Attachment D
Response to Transport for NSW advisory comments for consideration on the Response to Submissions (SSD 8784)

Figure 3-4 Proposed vehicular access and surrounding street hierarchy

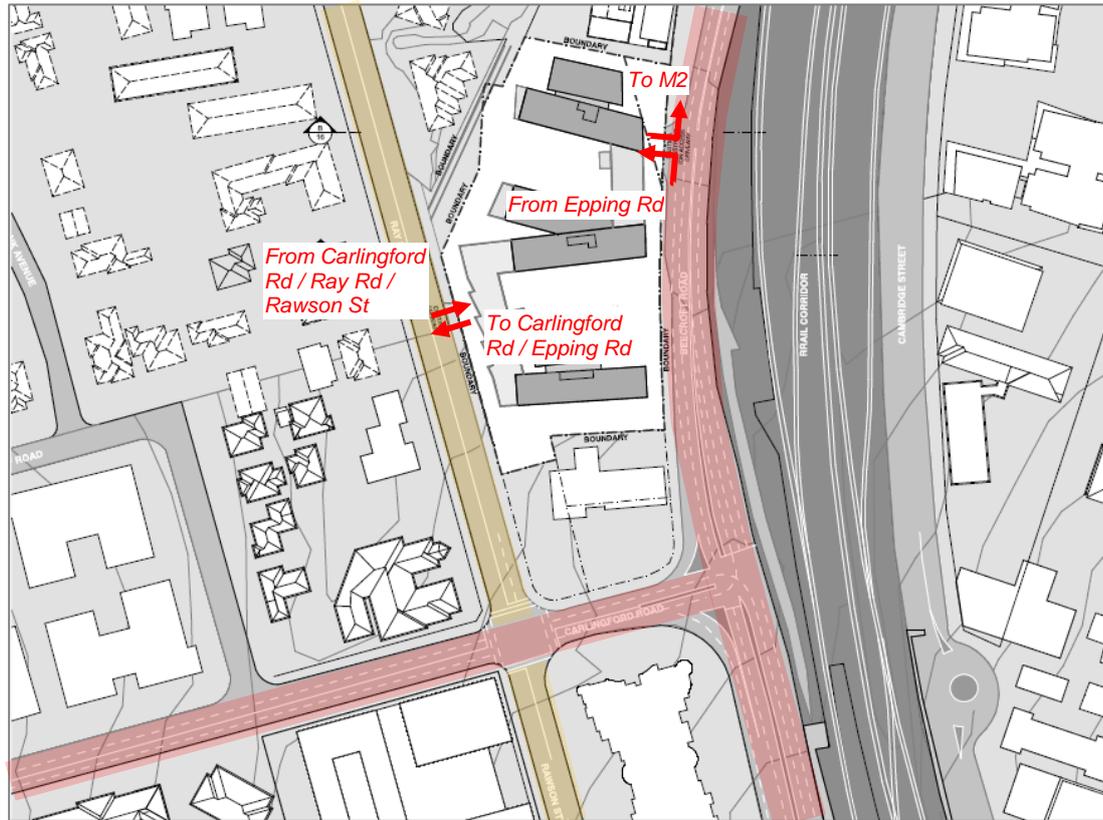
<p>2. <i>Additional details, shall be provided for the proposed vehicular crossover on Ray Road to ensure that there is no impacts to surrounding classified roads (such as queueing), visibility and safety for vehicles turning out, conflict with pedestrians, and conflict with vehicles turning right into the development and through vehicles (northbound).</i></p>	<p>The location of the proposed vehicular access at Ray Road is shown on Plan 3.04 (Attachment B).</p> <p>The proposed access is located just to the north of the existing driveway, where all movements (in and out of the driveway) are permitted. Given it is a small relocation of the existing driveway, impacts of the new vehicular access is expected to be negligible. A number of on-street parking spaces may require relocation (along the eastern side of Ray Road, north of the existing driveway) to ensure sightlines are provided for vehicles exiting the car park.</p> <p>Based on the trip generation, the majority of traffic are turning left from the proposed access into Ray Road in the AM peak. Traffic expected to be turning right from Ray Road into the car park in the PM peak is less than 12 vehicles/hour. There are a minimal number of vehicles expected to turn right out of the car park to Ray Road.</p>

Transport for NSW Comment	Response
	The additional details of the proposed driveway access at Ray Road including swept path analysis will be provided at detailed design stage and/or as part of the future development applications for the site.
3. <i>Consideration shall be given to the provision of double marked lanes up to Carlingford Road from the development access point on Ray Road.</i>	No changes are currently proposed on Ray Road, except the proposed car park access and driveway at Ray Road.

Figure 3-6 Proposed Beecroft Road left in / left out access with swept path analysis

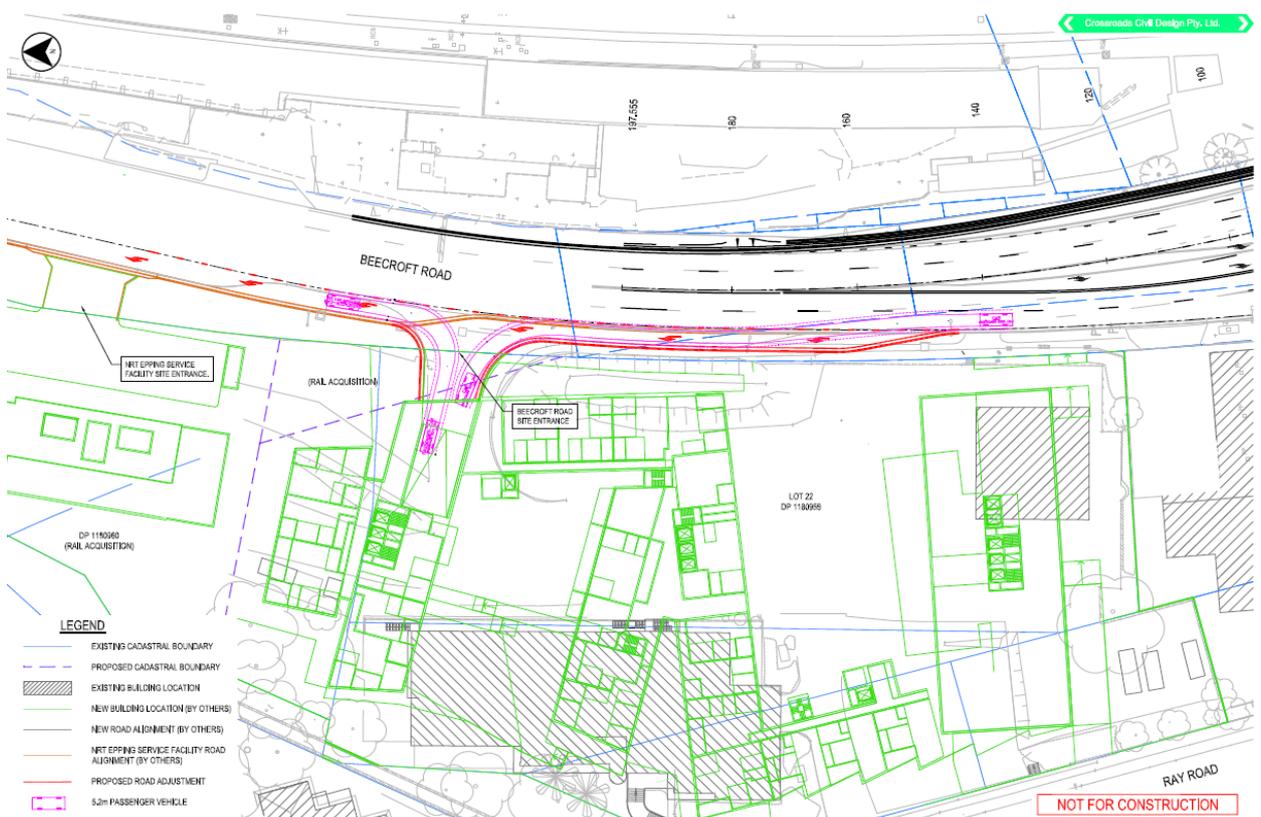
Transport for NSW Comment	Response
<p>1. <i>The proposed deceleration lane on Beecroft Road should be separated from the existing deceleration lane for the adjoining development. TfNSW regards this as a safety issue due to a continuous lane creating conflict between entering and exiting vehicles. Additionally, this increases the opportunity for this lengthened lane to be used by through vehicles bypassing slower traffic on Beecroft Road.</i></p>	<p>The proposed access to and from Beecroft Road will be a left-in/left-out priority intersection to minimise traffic conflicts on Beecroft Road. The concept and the design of the proposed access at Beecroft Road has been developed in consultation with Roads and Maritime Services (now integrated as part of Transport for NSW). The proposed left-in movement at Beecroft Road will be provided via a deceleration lane of approximately 30 metres in length to allow entering traffic to slow down without interfering with through-traffic on Beecroft Road.</p> <p>Vehicles exiting the development can only turn left onto Beecroft Road. They will have clear sightlines to oncoming vehicles on Beecroft Road travelling northbound and/or traffic entering the Epping Services Facility (ESF) before safely entering into Beecroft Road traffic. Due to the small number of vehicles expected to turn left from the driveway access (less than 10 vehicles per hour during the peak periods), any potential conflicts with traffic entering the site or the ESF, as well as traffic on Beecroft Road, is considered minimal.</p> <p>A splitter island can be designed at the proposed car park access of the proposed development to facilitate left-in/left-out movements between Beecroft Road and the car park of the development, which would also prevent traffic from entering the new deceleration lane to the ESF.</p> <p>Landcom would accept a condition of consent that requires the provision of a splitter island (or similar road infrastructure) to be incorporated as part of the development.</p>
